From: Lucy Harding
Sent: 04 April 2017 10:19
To: Planning.Responses
Subject: FW: AL/107/16 RES Land west of Westergate St and east of Hook Lane

From: Paul Cann
Sent: 03 April 2017 17:32
To: Lucy Harding
Cc: Thomas Callaway
Subject: RE: AL/107/16 RES Land west of Westergate St and east of Hook Lane

With regards to the above application, we would like to raise concern over the development layout, as the surface water drainage proposals shown do not represent an agreed strategy at this time. There are a number of issues with the current drainage design, and one of the most fundamental is that the run-off from the site does not mimic the anticipated green field characteristics. Based upon their 'Drainage Strategy & SUDS statement, a majority of the site falls to the South East corner, where we suspect there is a buried outfall pipe or infilled ditch, heading south towards Hook Lane. The remainder of the site falls to the Eastern outfall and the North Eastern outfall. The current proposal is to only discharge to the Eastern and North Eastern outfalls. This is a concern, as the strategy does not replicate the sites fundamental flow regime, as would have been recognised when the field w

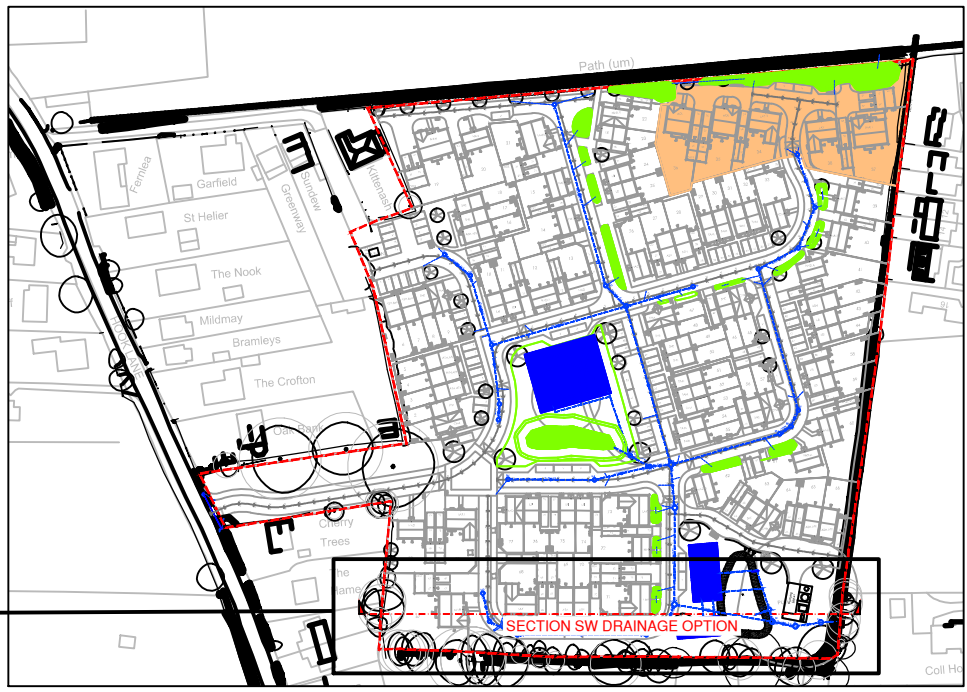
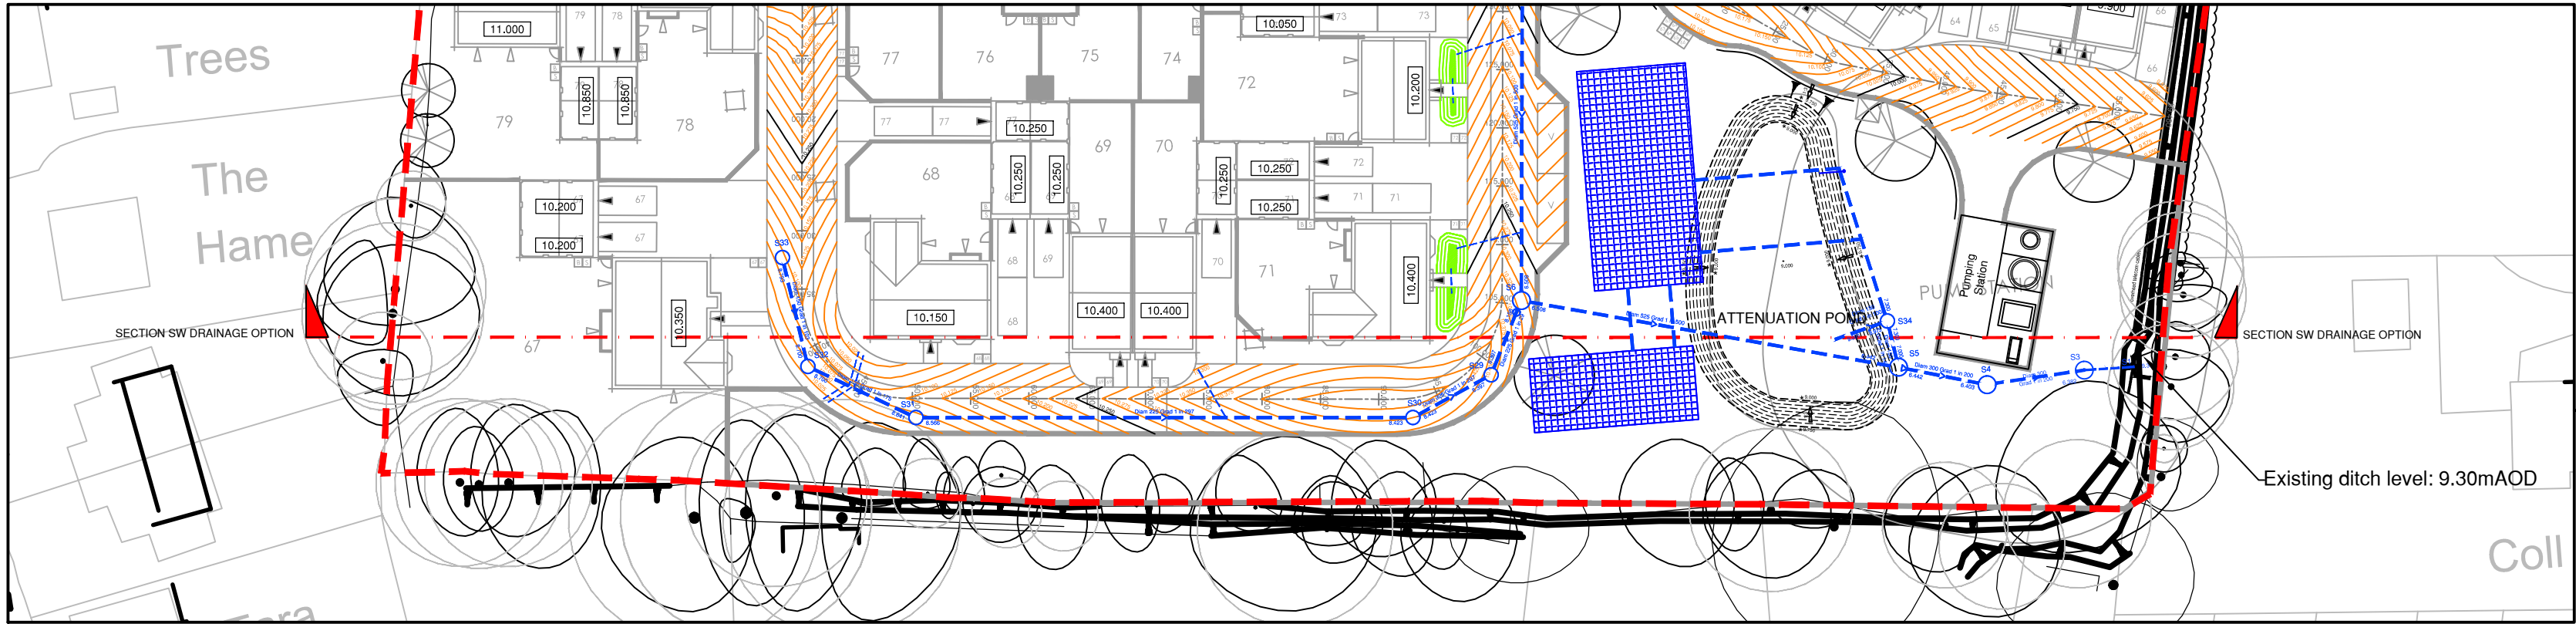
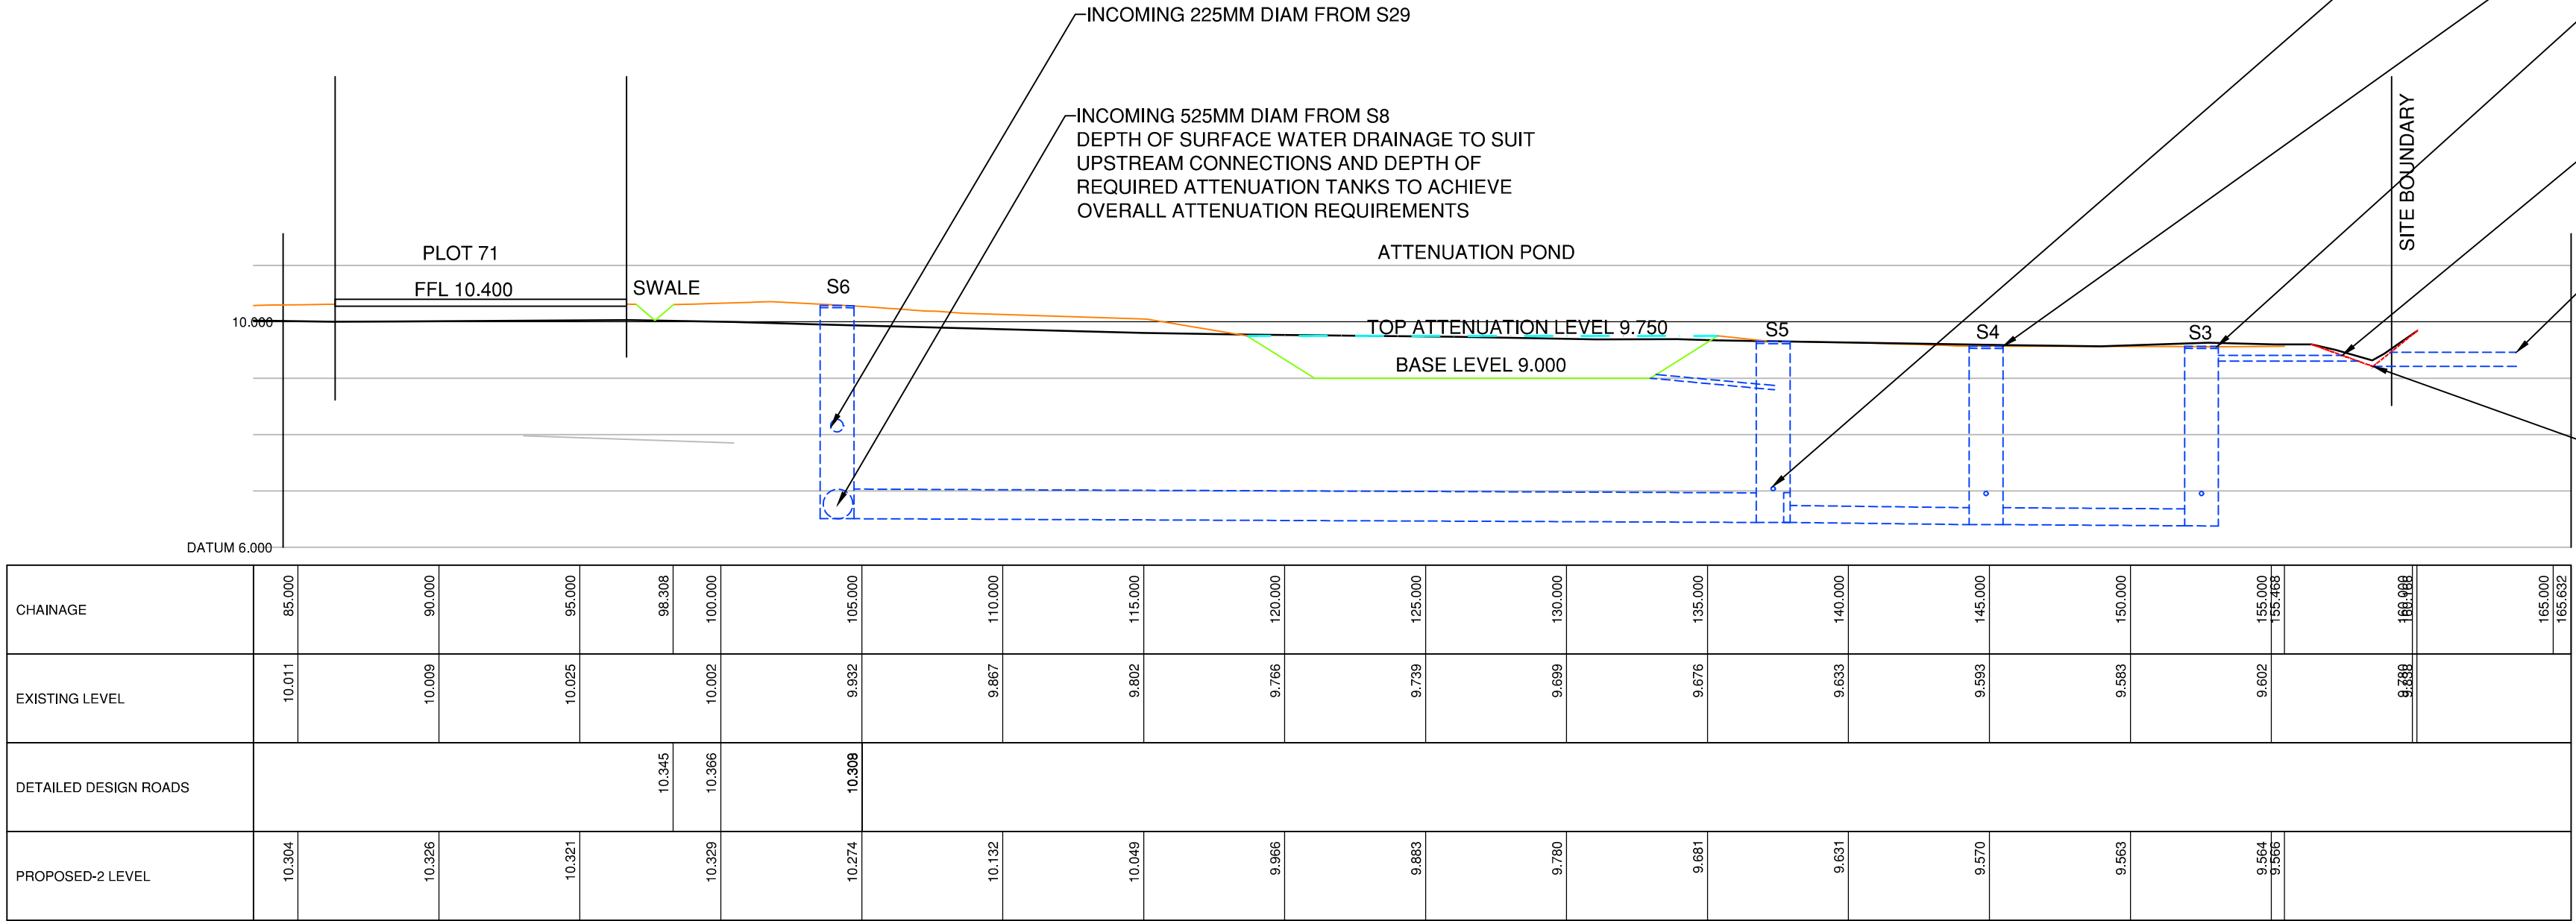
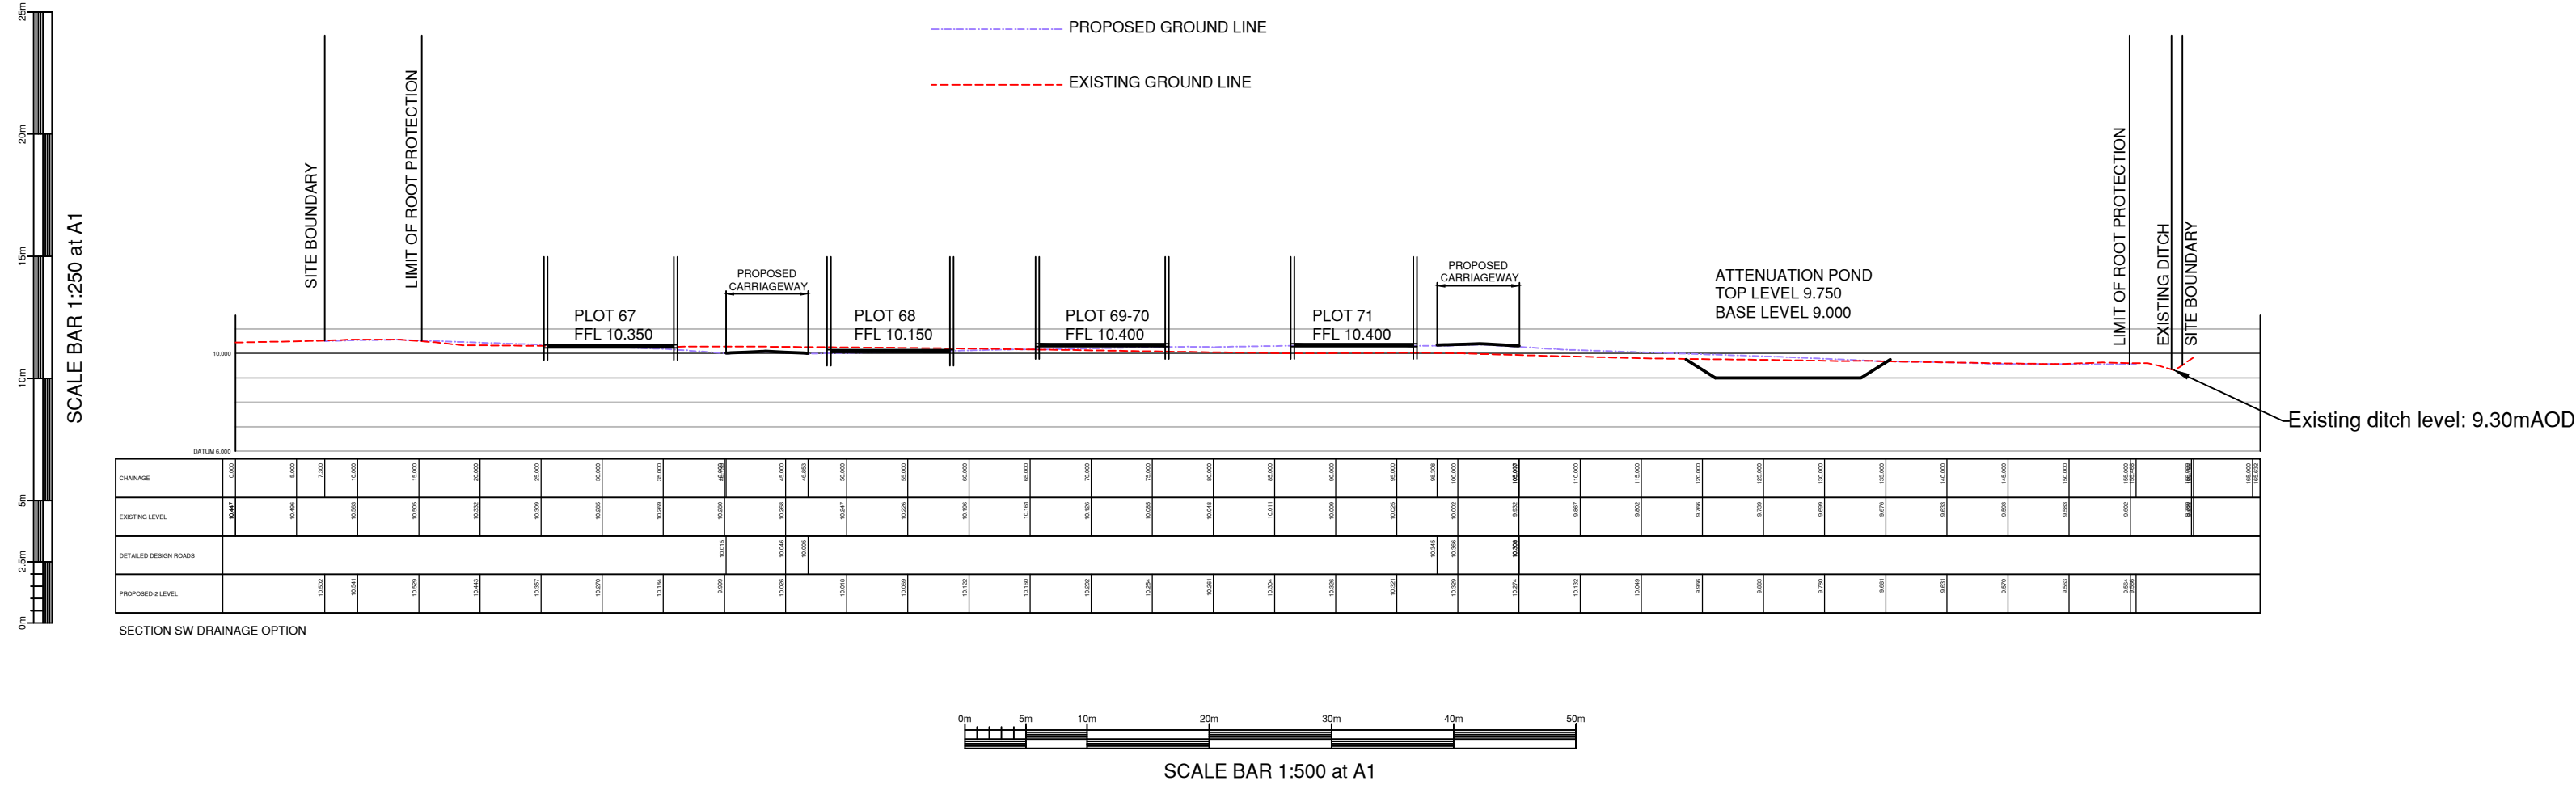
1. Have any investigations been carried into the use of permeable lined pavements for the entire estate road in order to reduce the depth of the drainage infrastructure, and thereby minimise the risk of the effects of groundwater ie. infiltration into pipes, etc, and floatation of structures ie. lined ponds and crated tanks. The design largely relies upon the transportation of water via a conventional piped system with conventional road gullies, which has created a system that is unnecessarily deep. This may have already been looked at by the consultant acting for Barratt's, if so, I am not sure why it was discounted. It is noted that permeable parking areas and swales have been utilised in places but their connectivity to the system is not shown in any detail.

2. A full investigation into the existence/invert level of any existing outfall in the South East corner has not been carried out. This aspect, together with item 1 above (if deemed an option), could significantly affect the design.

3. There is no drainage scheme shown for the access road from Hook Lane and this area doesn't appear to be accounted for in the allowable greenfield run off rate. This could therefore potentially increase the agreed rate from the site.

4. Investigating items 1 and 2 above, could impact on the pumping proposal.
5. Open ponds are preferred to the use of crates, where feasible.
